# PORTLAND MAINE

July 15, 2011

RE: 171 Warren Avenue  
Project ID: #10-79900021

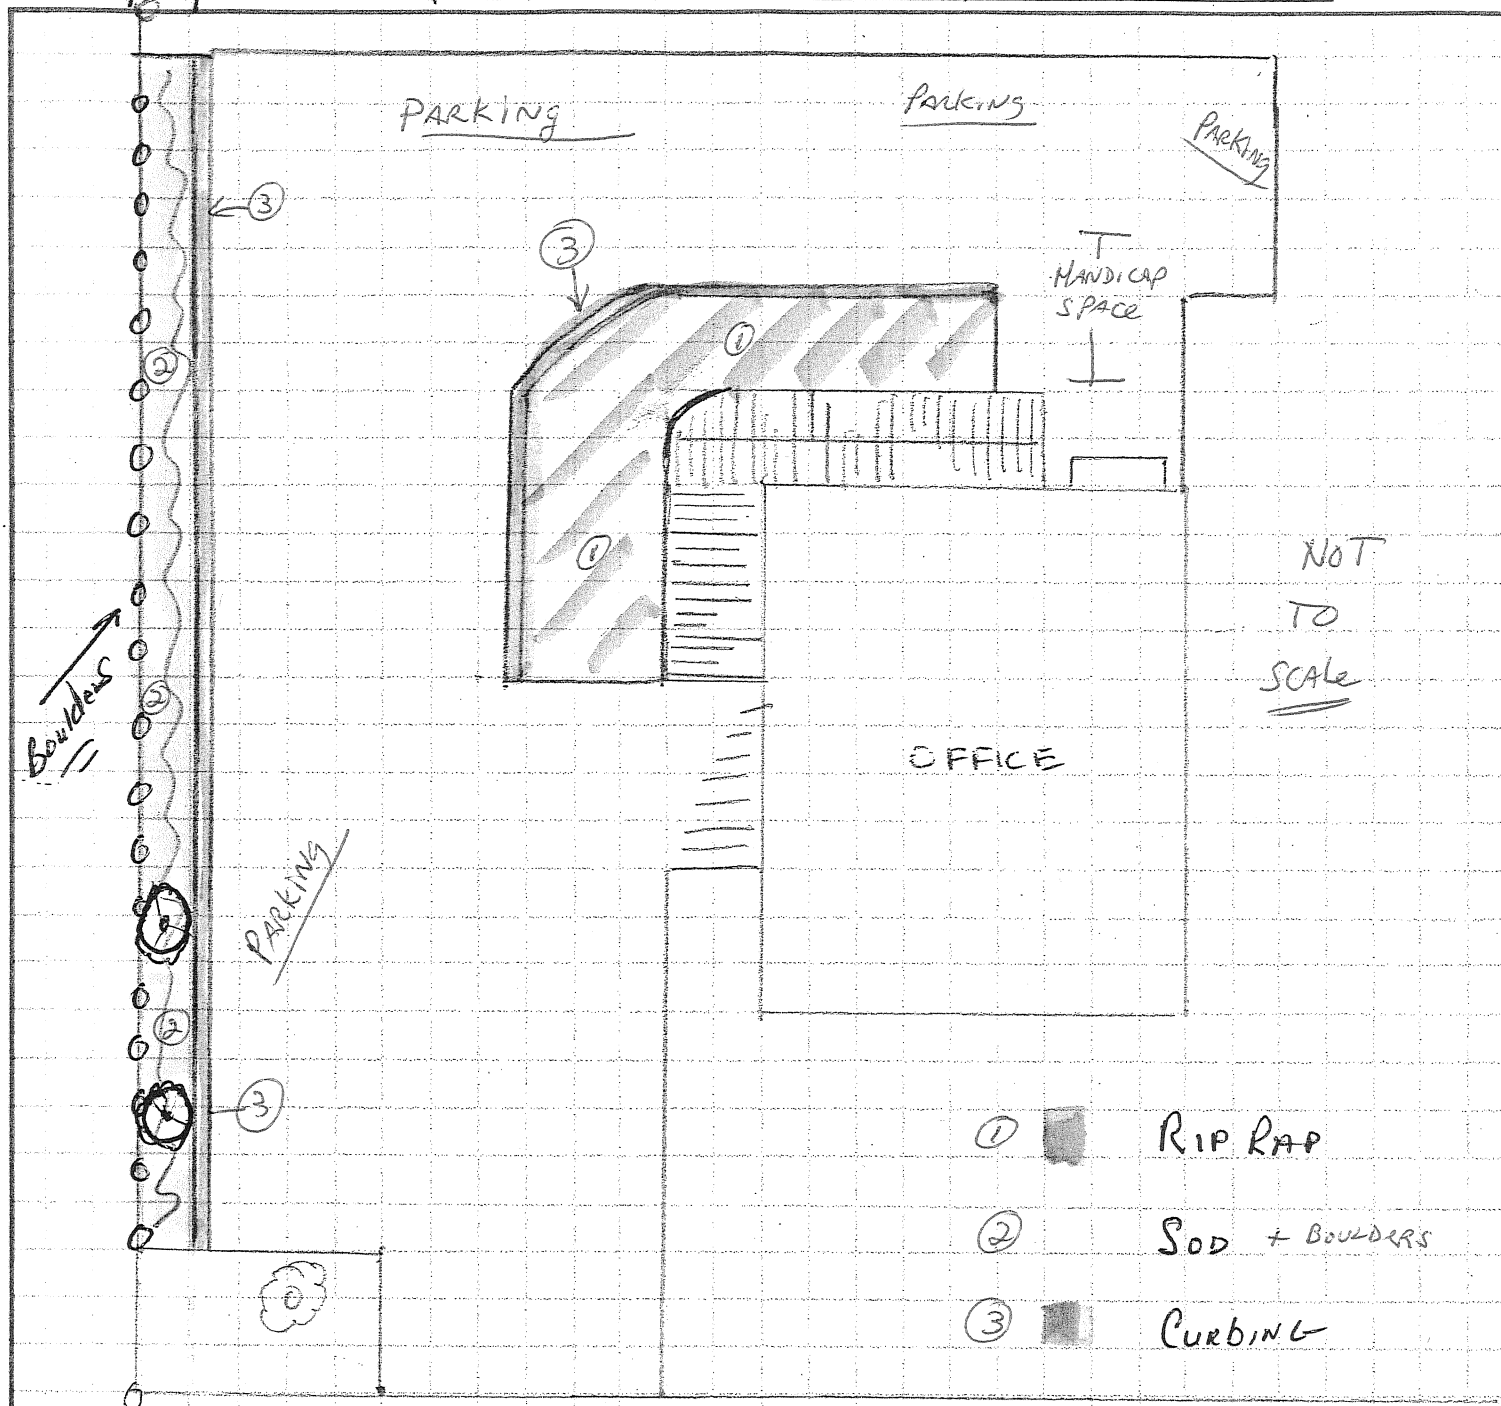
1. Removing a berm that was installed, but not proposed as part of the original site plan. The proposed revisions show returning this to a grassed area consistent with the original approval;
2. Installing boulders along Hemingway Street to limit cross through traffic;
3. Adding a bituminous curb along the parking lot edge, parallel to Hemingway;
4. Adding pavement to the parking area at the rear to square it off;
5. Installing rip rap as erosion control in the grass knoll to eliminate erosion.

1. To the left of the driveway, along Hemingway Street, we will remove the exiting berm (dirt and bark mulch), lay in a bituminous curb (on the driveway side of the divider) with sod and bolders. This will be more pleasant a presentation then the mound I had created and will prevent local traffic from cutting through the property. The contractor is grading properly so drainage occur. The boulders will compliment the rip rap rocks near the wheel chair ramp for a better looking presentation.

2. In the back of the property, where old pavement exists, we are squaring off the property, removing the old pavement and laying proper gravel and pavement graded appropriately for drainage so exiting areas that puddled are eliminated.

3. By the existing Handicap Parking space, we will extend the pavement so that the vehicle can have easy back up and turn space without affecting other parked vehicles

4. Now, how to explain the "grassy knoll". I was able to remove that dirt. This will allow us to move the driveway access to the back parking area by placing it closer to the building/wheelchair ramp. This will make for better access, in case of emergency, since traffic will not have to go around parked cars as much. To cover the exposed dirt and ledge (near and under the wheel chair ramp), we will install "rip rap" with appropriate

drainage ability. Along the bottom of the rip rap, the contractor suggest installing a bituminous curb to hold the rip rap in and give a clean & finish appearance. This will compliment the bituminous curb on the other side of the driveway.

On July 15, 2011, the proposed revisions are approved as minor revisions to the approved site plan with a condition of approval that the final set of plans be revised to accurately reflect the revisions. All other conditions and standard conditions of approval from the August 27, 2010 approval shall apply and the performance guarantee or defect guarantee shall not be released until the updated final plans are submitted. **Please be advised that if you are considering any other revisions to the site, you will need to submit an application for a new or amended site plan.**
